**Planning application no: 3/2014/0300.**

**Proposal:** Outline Application with some matters reserved for proposed construction of 28 no. residential properties.

**Location:** Land off Mill Lane Gisburn BB7 4LN

PROPOSED SITE PLAN	
Site: Proposed Development Land off Mill Lane Gisburn	320140300?
Client: Mr Guy Hindley	
Date: 31-3-2014	Scale: 1:1000 @ A1
Project No: J348-Access-Flg1	Drawn: AD
Amendments:

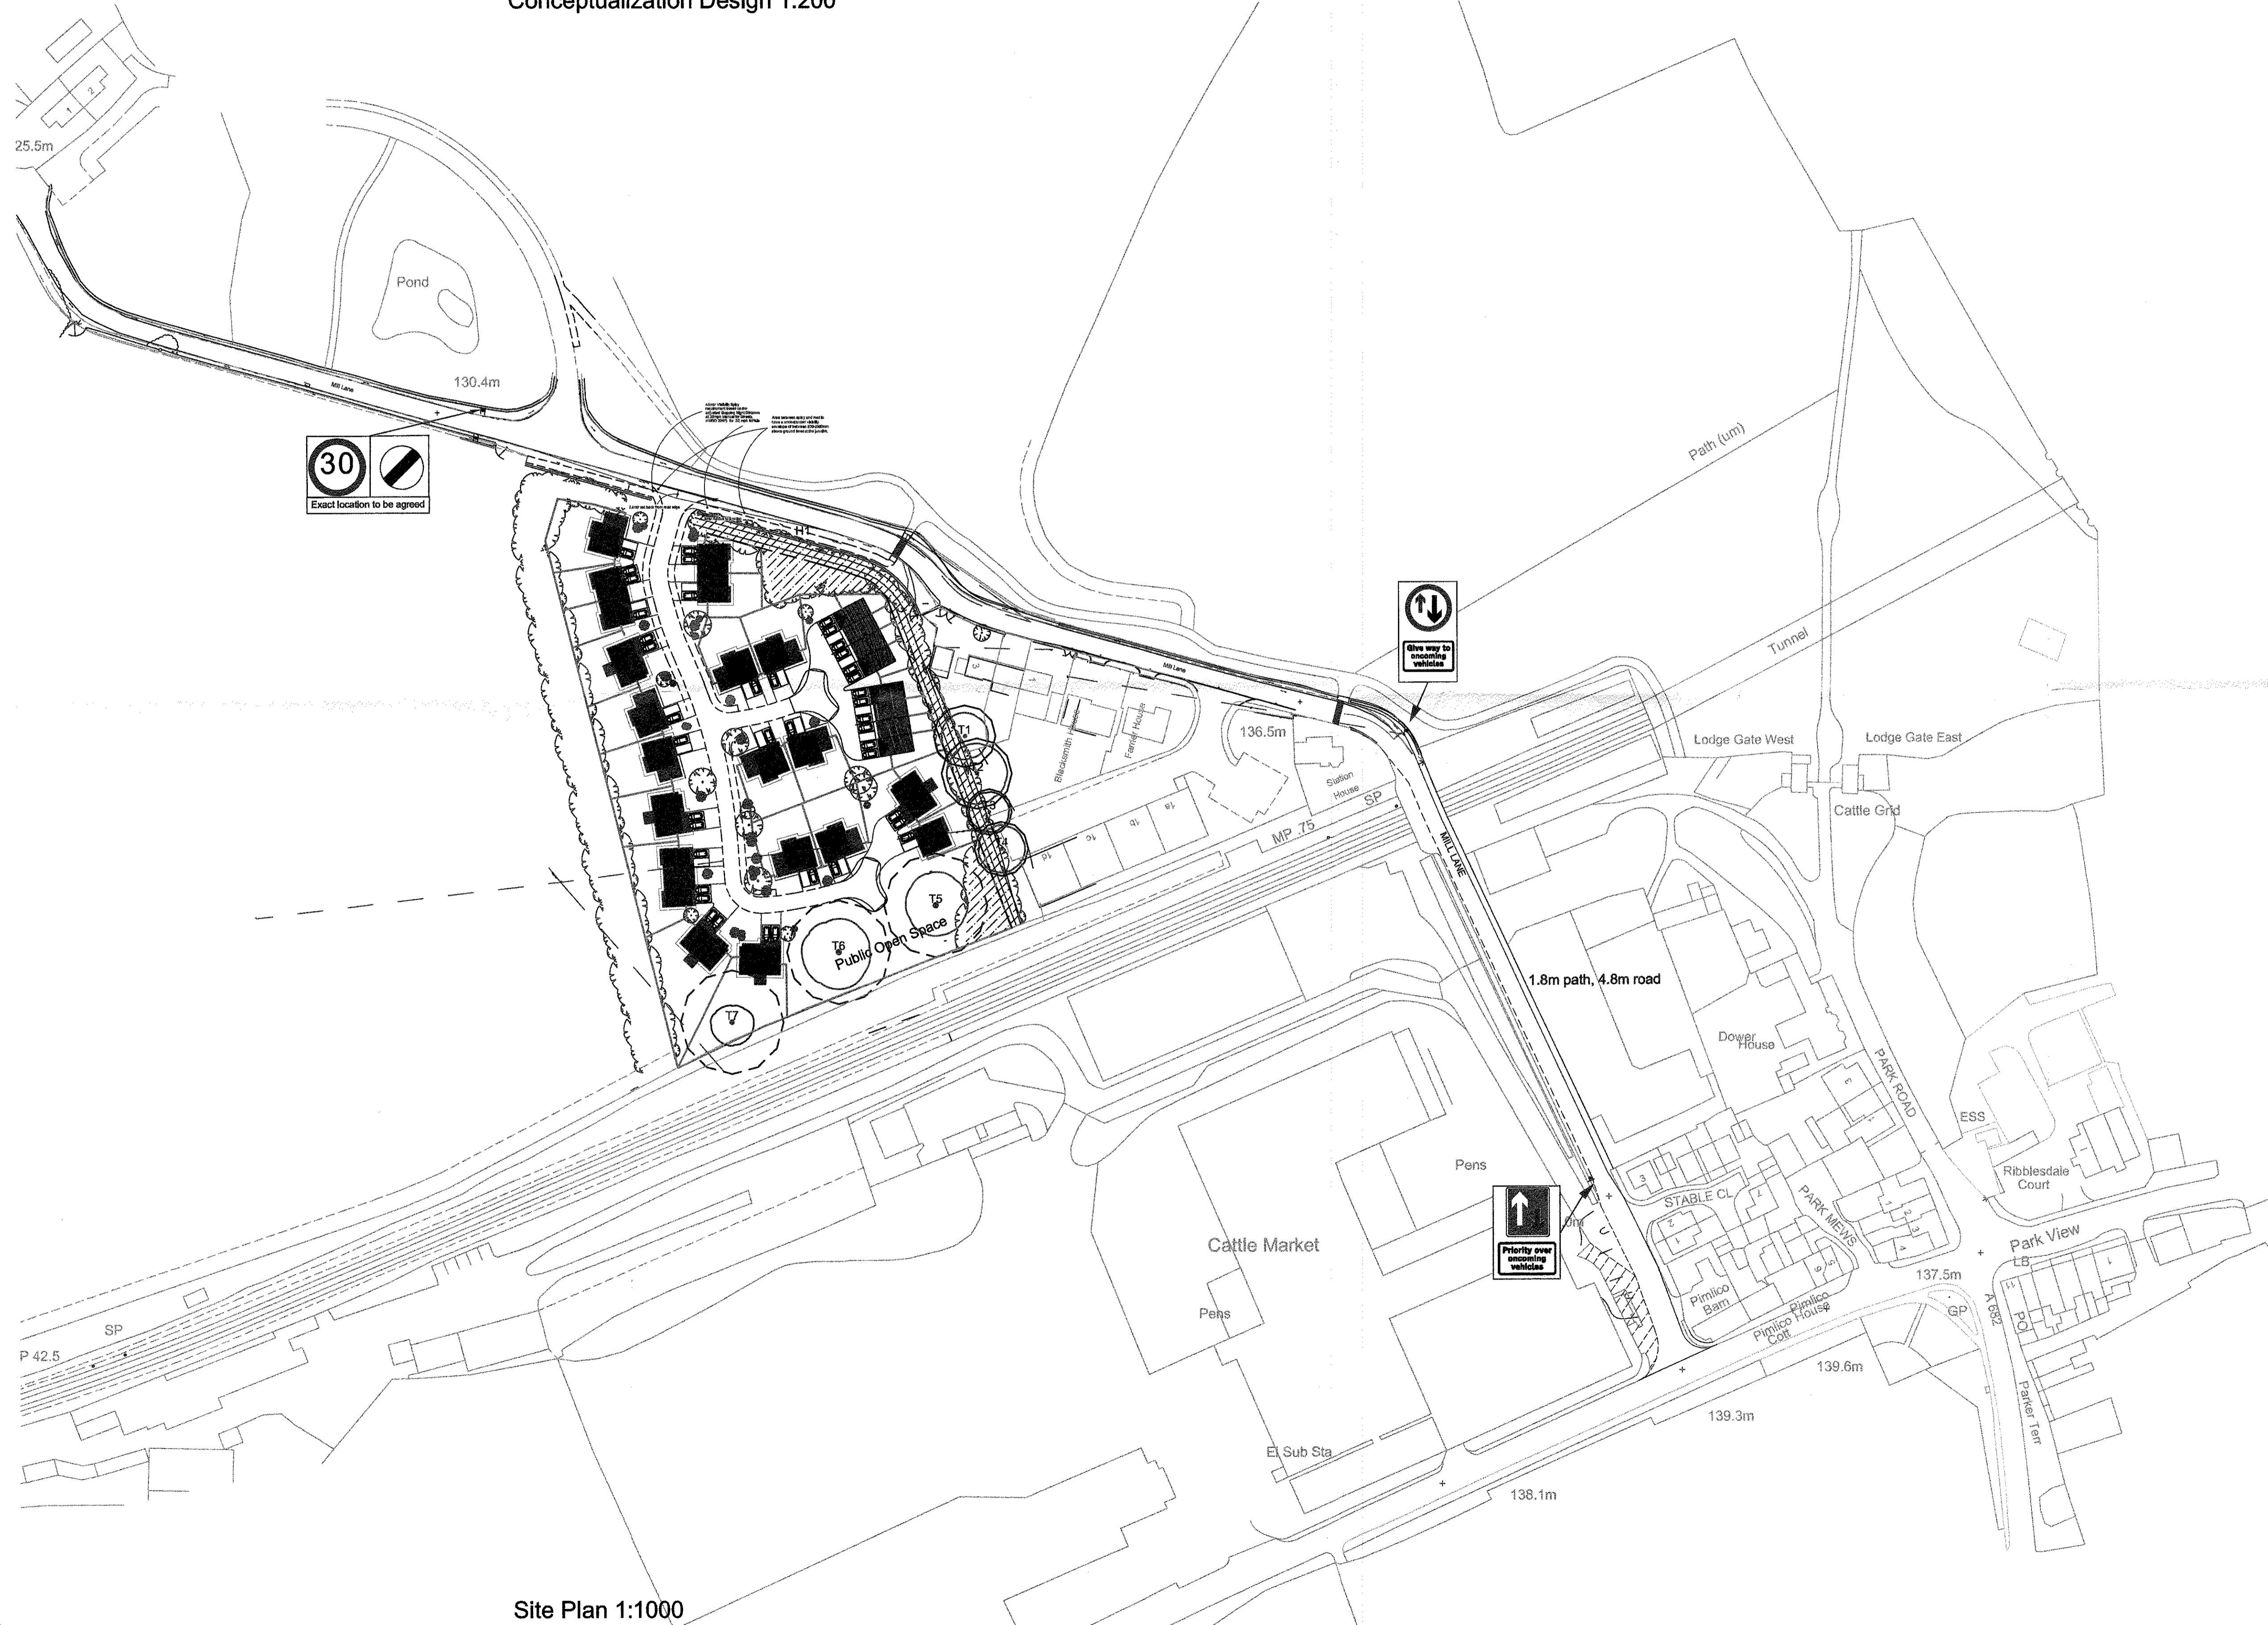
The proposed one way working along Mill Lane is not favoured and should be deleted from the highway improvements.

There is some risk driving out of Mill Lane because the visibility to the left is sub-standard, being approximately 2.4m by less than 20m. Mill Lane at this junction is fairly wide, about 13m wide. The traffic lane in Mill Lane approaching A59 is of the order of 3.5m wide, meaning that there is about 10m for traffic turning off A59 into Mill Lane. The developer has proposed extensive hatching in Mill Lane at this junction. However, there would be some advantage in moving the south-bound traffic lane in Mill Lane to the west as far as possible as this would then improve visibility to the left at the junction with A59. I would ask the developer to provide a sketch design for this alteration for my consideration, showing what improvements to the visibility may be possible and showing that sufficient space will remain for trucks turning left off A59.

A footway should be provided along the south side of Mill Lane along the site road frontage. This should be constructed up to the boundary with No 3 Smithy Cottages. From this point towards the east, a footway should be provided within the highway on the northern side of the carriageway. The footways on the north and south side of the carriageway should overlap to provide an opportunity for pedestrians to cross the carriageway. The location of the overlap should be checked for visibility along the highway to provide sufficient forward visibility for traffic on Mill Lane and also to provide visibility along the highway for pedestrians wanting to cross the road.

The Mill Lane carriageway should be a minimum of 5.5m and the footway, on one side of the carriageway only, should be between 1.2 and 2m wide, depending on the overall width of the highway. This footway should extend on the north and east side of the carriageway to the existing footway in Mill Lane near to A59 junction.

The proposed one way working proposed along Mill Lane is not favoured and should be deleted from the highway improvements. This will not be necessary if the suggestions set out above are used.

It is not clear whether all the estate roads shown on the layout drawing will be adopted. If all the estate roads are to be adopted, the layout is acceptable. If some of the estate roads are not to be adopted, then a turning head will be required at the end of the adopted estate road.

If no footway is to be provided along parts of the adopted estate road, then a service strip 2m wide will be required. Parking spaces should not encroach over a service strip.
